From: Chima Umannakwe <Chima.Umannakwe@arun.gov.uk>
Sent: 07 October 2021 12:54
To: Planning.Responses <Planning.Responses@arun.gov.uk>
Cc: Michael Eastham <Michael.Eastham@arun.gov.uk>
Subject: LU/253/21/DOC

I refer to the above application to approve details reserved by the conditions imposed under LU/47/11/ relating to Condition Nos 37 - noise mitigation and 38 - noise levels.

Drawing Title:
Acoustic Boundary Fence

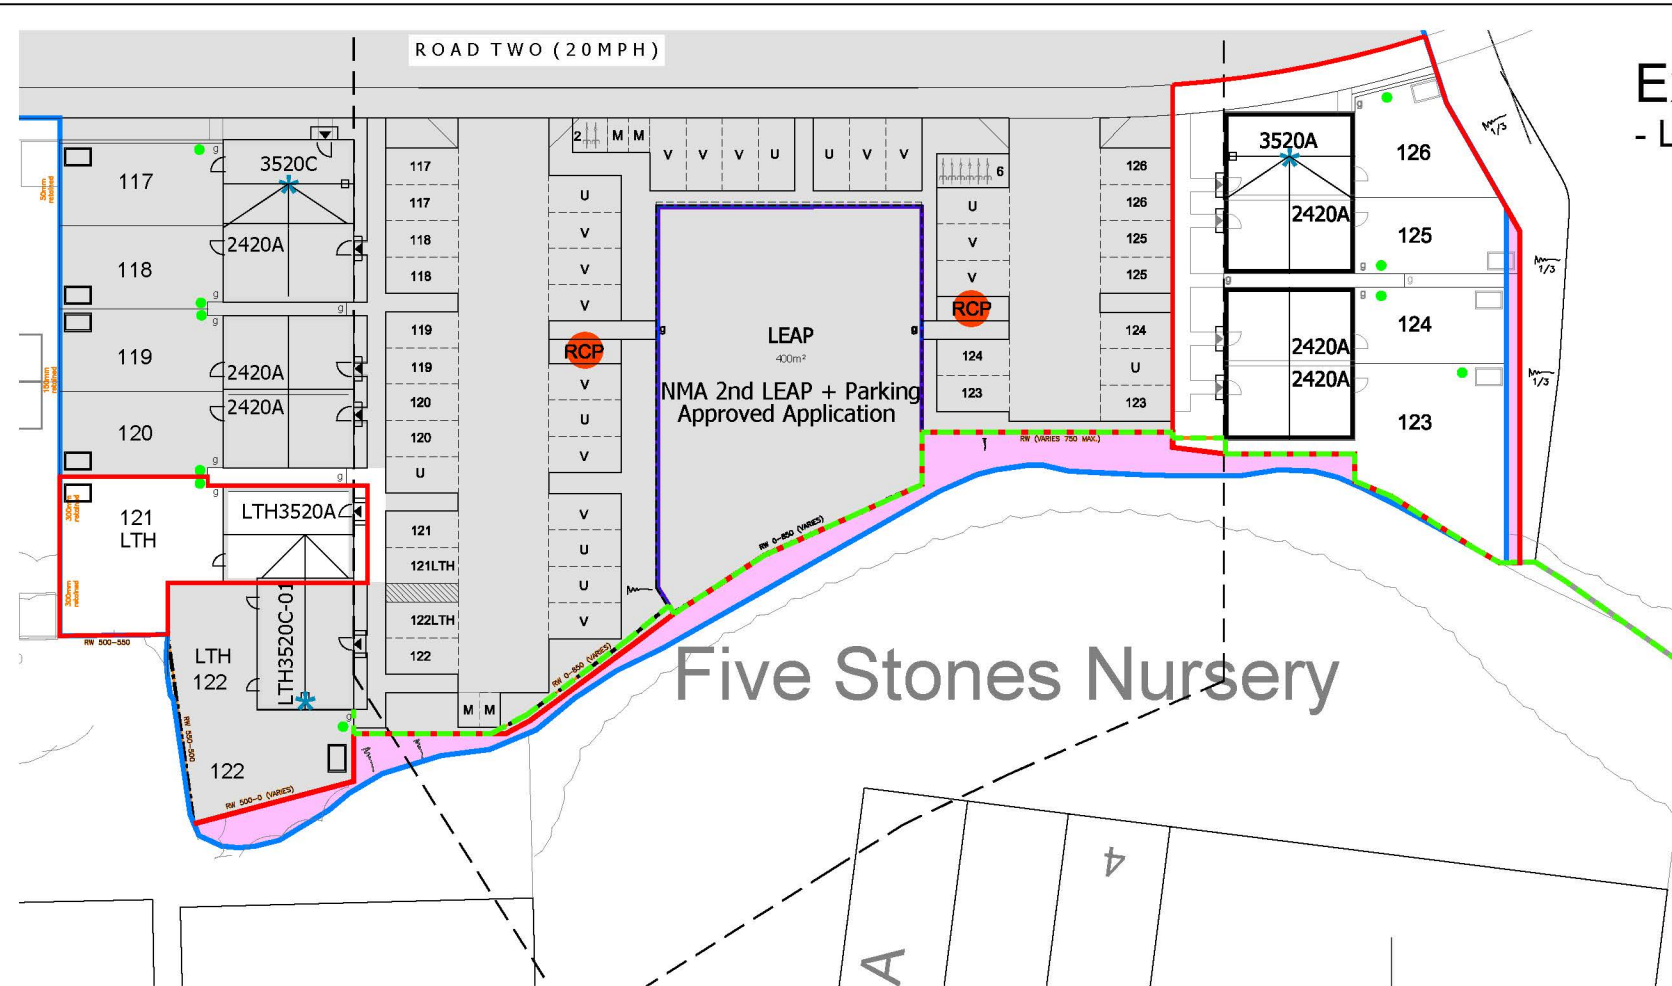
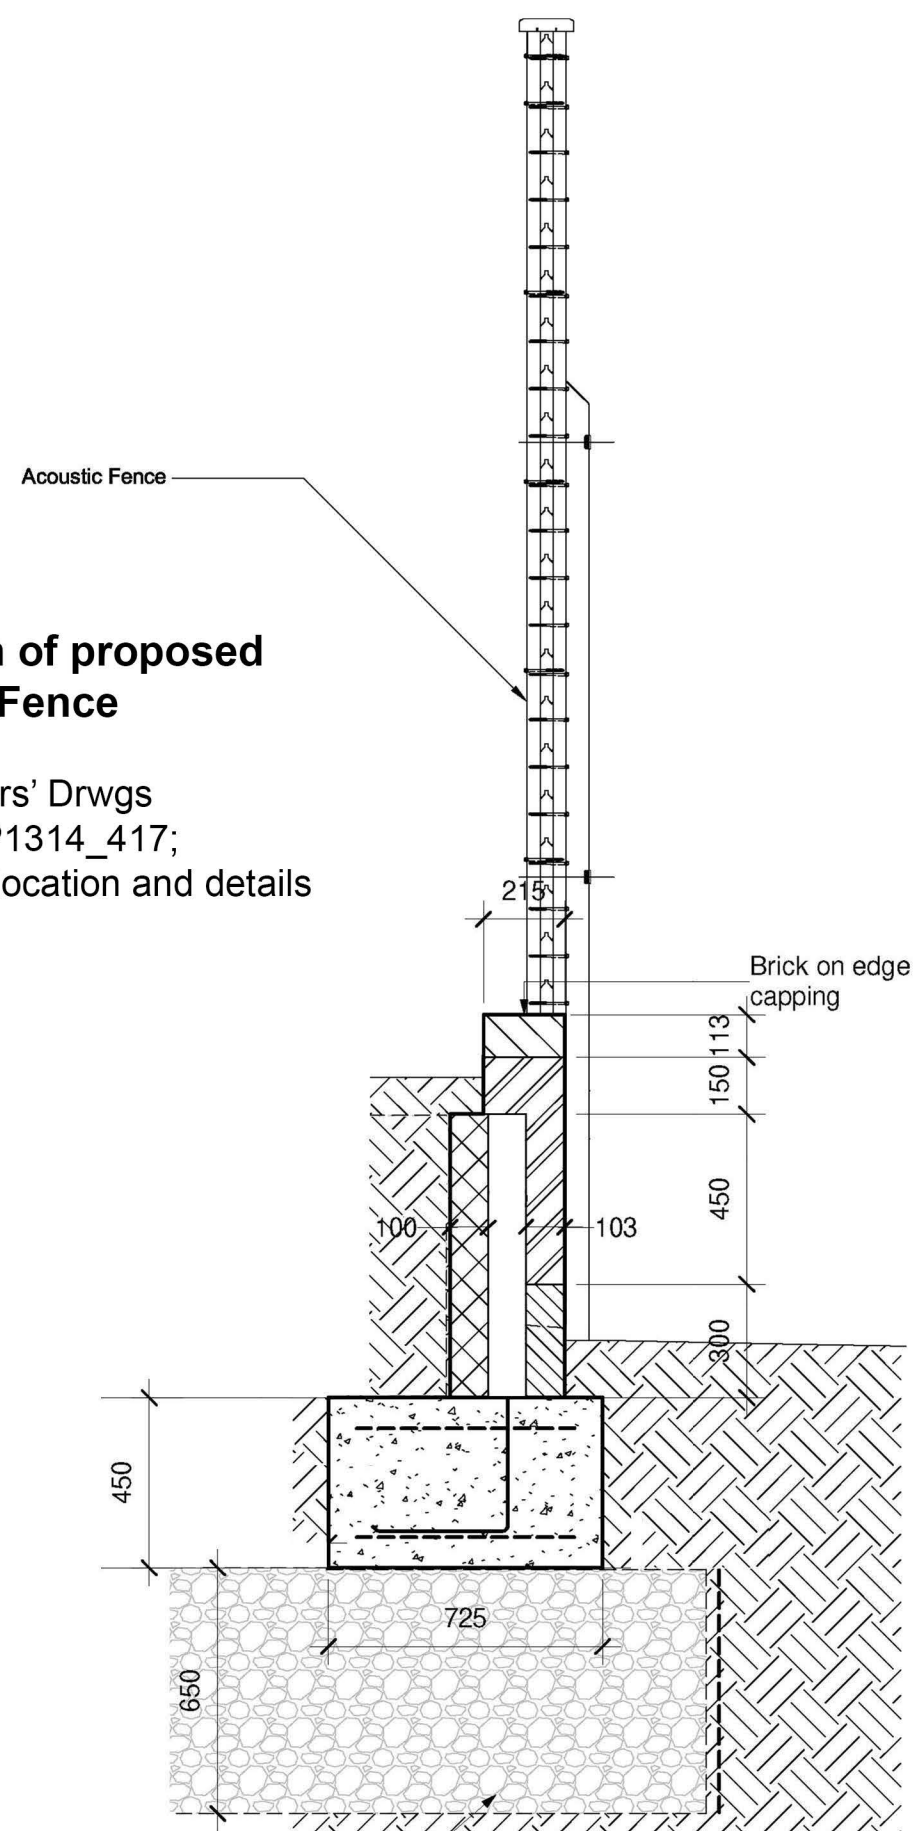
I have reviewed the applicant's noise report prepared by Wyg dated December 2019. The initial assessment indicated a marginal high assessment score under BS4142 2014, potentially impacting noise-sensitive receptors adversely. The introduction of the 2.8m high noise barrier along the northern boundary of the commercial premises provided adequate noise mitigation against noise from the commercial premises. The noise data provided post-installation of the noise barrier showed that it is unlikely to affect the receptor locations.

Accordingly, conditions 37 and 38 may be discharged.
